Please ask for: Ms Iqraa Malik
Email: iqraa.malik@terraquest.co.uk
Telephone: 01212341390
Our Ref: AW/276/21/HH
Your Ref:
Date: 17th August 2021

Application for Planning Permission for Works or Extension to a Dwelling

Development: Erection of side/rear extension to provide attached annexe and conservatory and conversion of existing side conservatory to garden room
Location: The Quest Cypress Way Aldwick PO21 4DF

PROPOSED WORKS	DRAWING	LOCATION
Attached Annexe/Conservatory Conservatory to Garden Room	1. Ground Floor Plan – Existing & Proposed Scale 1:100 @ A3 – Revised 20210912	The Quest, Cypress Way, Bognor Regis, West Sussex, PO21 4DF

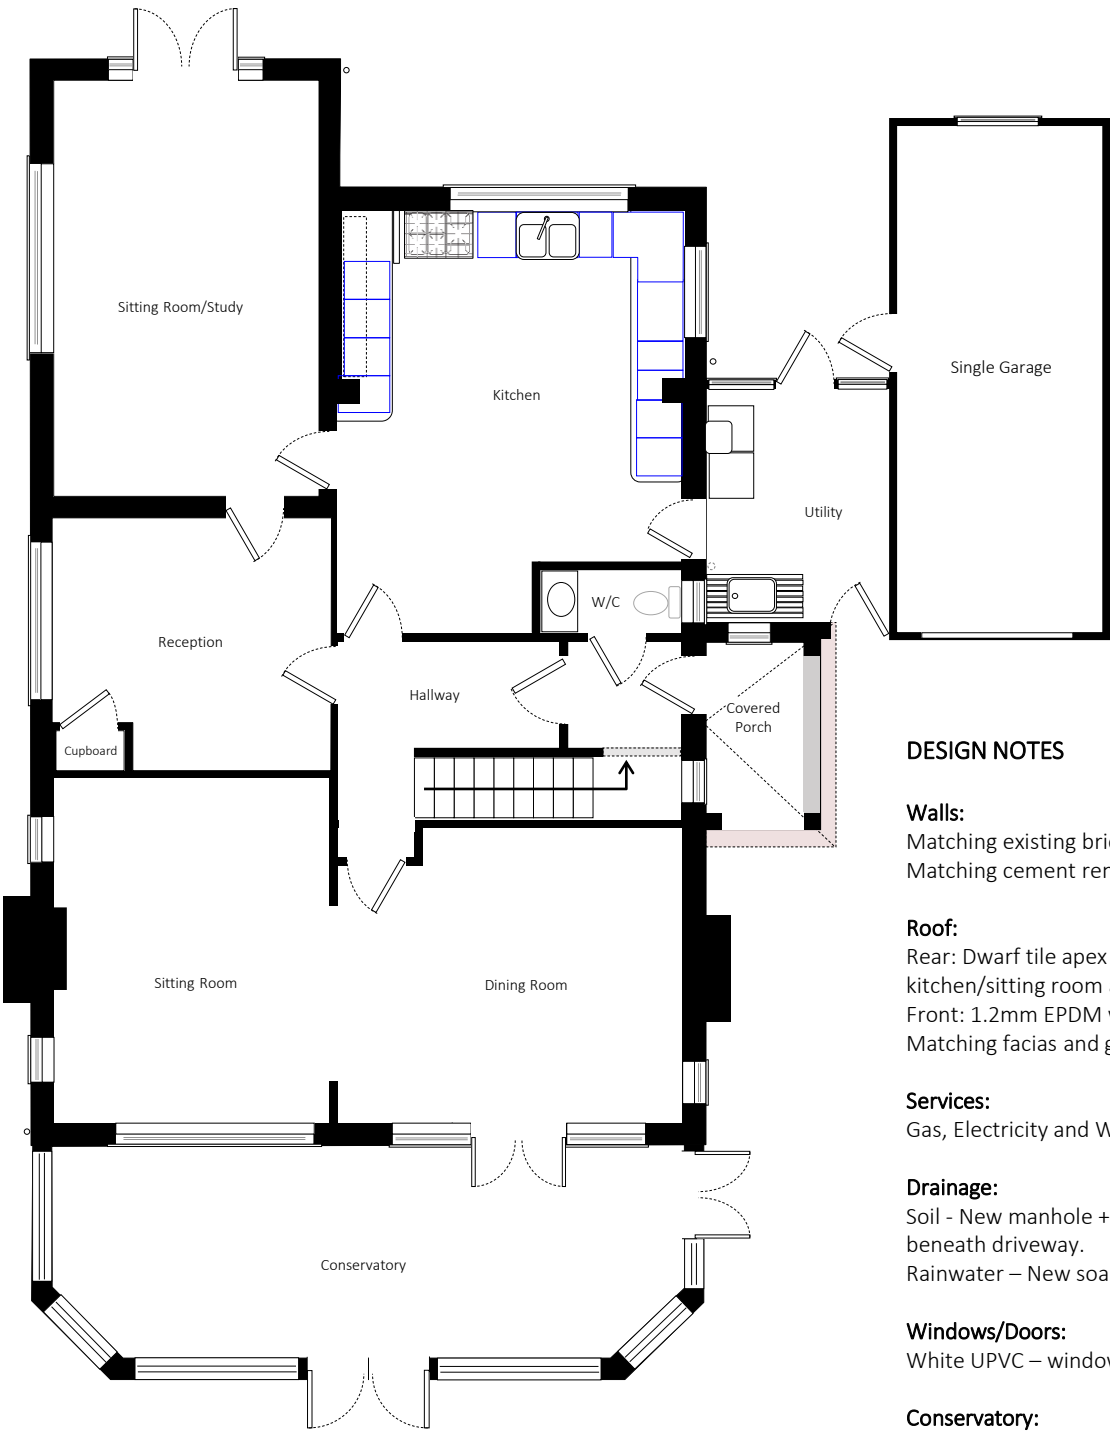
The windows next to the utility door on the existing and proposed north elevation are missing from the existing and proposed ground floor plan. Along with this, garage window on the existing and proposed north elevation and the garage door on the existing and proposed south elevation are missing from the existing and proposed ground floor plans. Please review and amend accordingly.
